**DELEGATED DECISION TO DETERMINE PLANNING APPLICATIONS TO  
CARRY OUT DEVELOPMENT WITHOUT COMPLIANCE WITH PLANNING  
CONDITIONS PREVIOUSLY ATTACHED**

Reference No:	<b>2024/70/91006/E</b>
Site Address:	Fox's Biscuits Ltd, Wellington Street, Batley, WF17 5JE
Description:	Variation of condition 2 (plans) on previous permission 2022/92292 for installation of replacement windows
Recommending Officer:	Elenya Jackson

## **Officer Report**

EAST ELEVATION AS PROPOSED

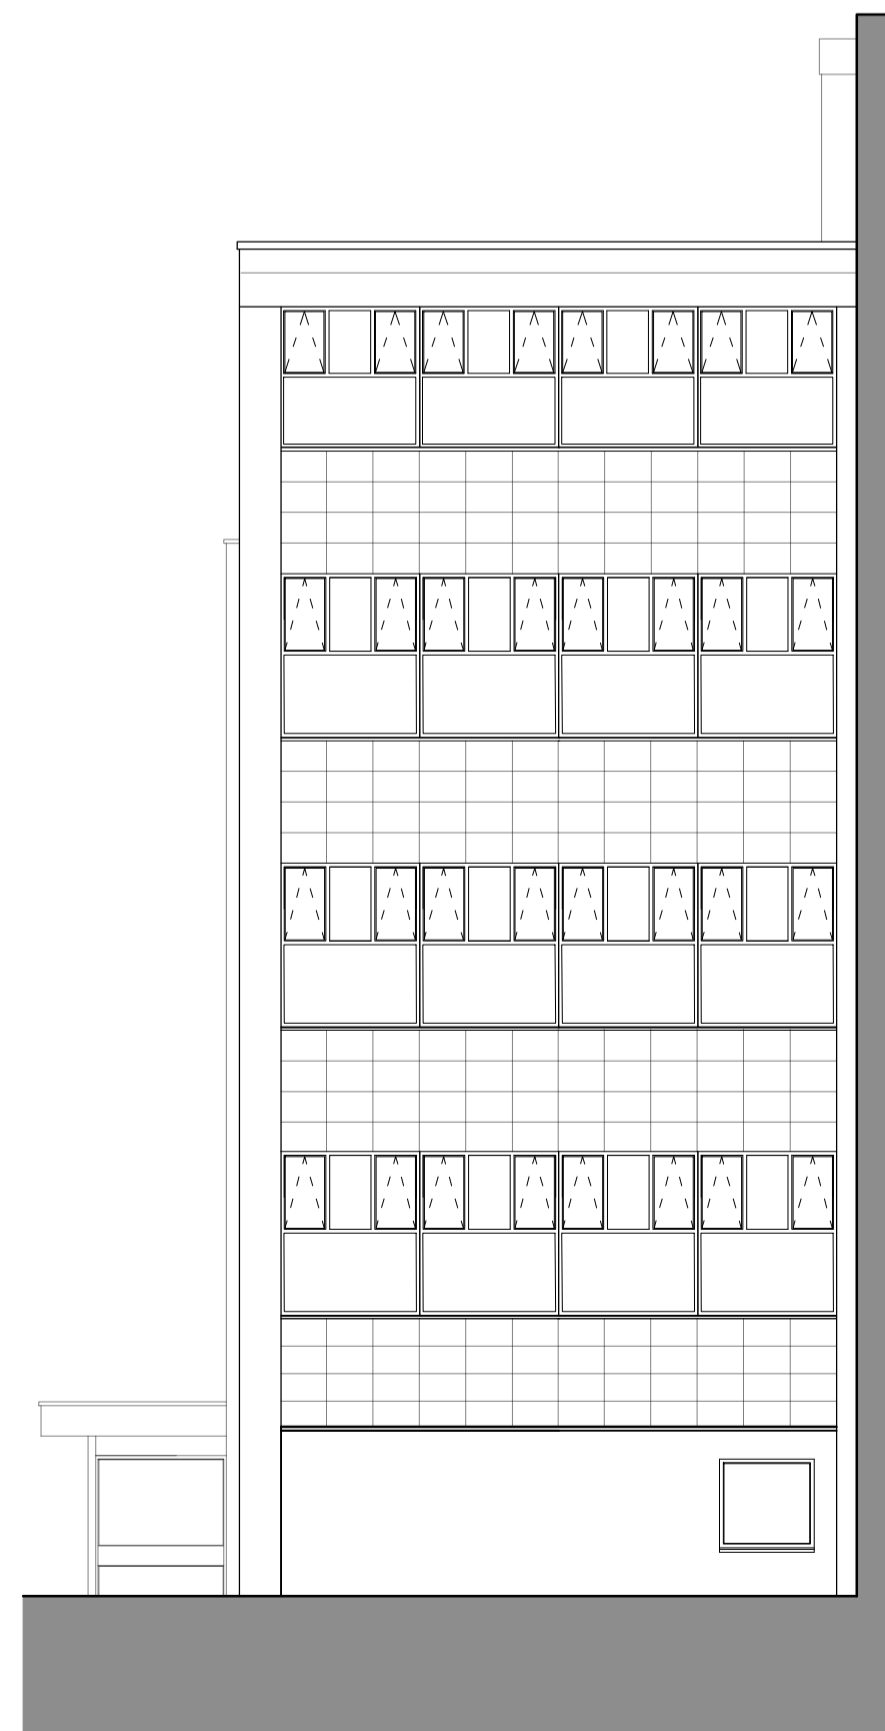
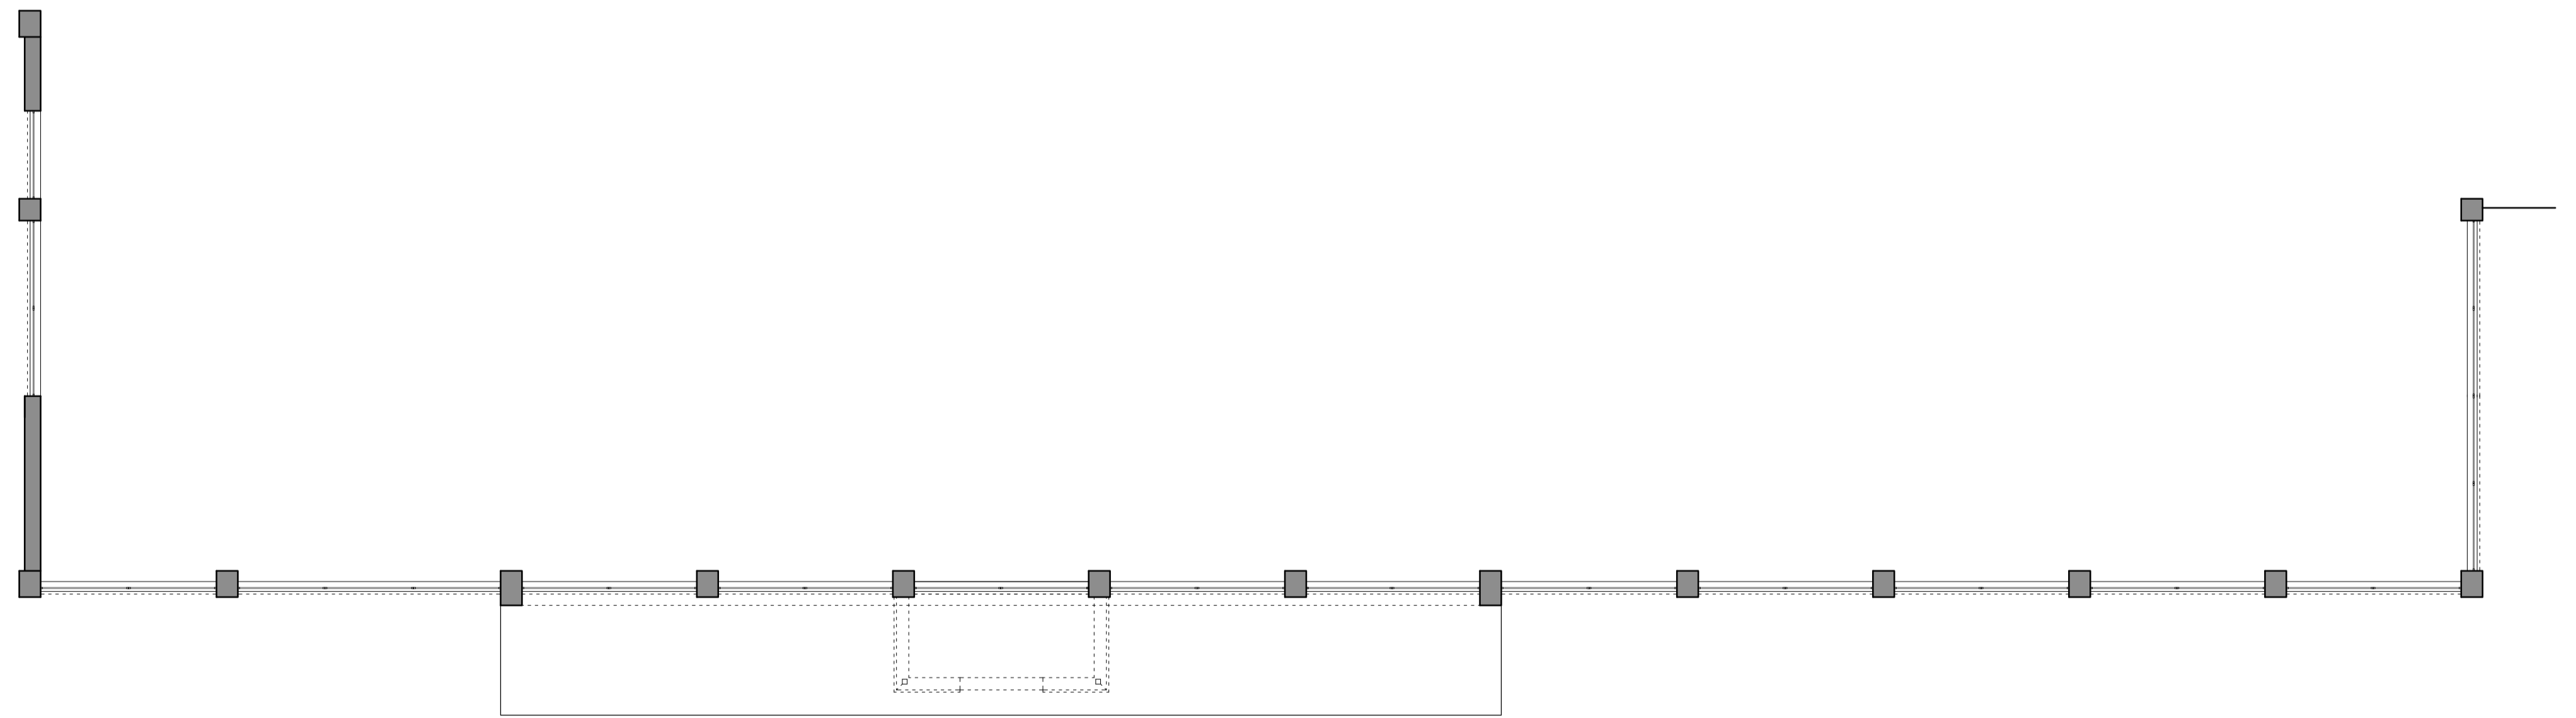
Previously, the proposal was approved for new windows in several elevations of the building. The proposal requests further windows to be replaced and the previously approved glazing profile to be amended to feature three panes in the top portion of the window which are larger in height.

Officers have reviewed the plans and consider that the alterations would not be result in any detrimental to visual amenity when considering the context of the site.
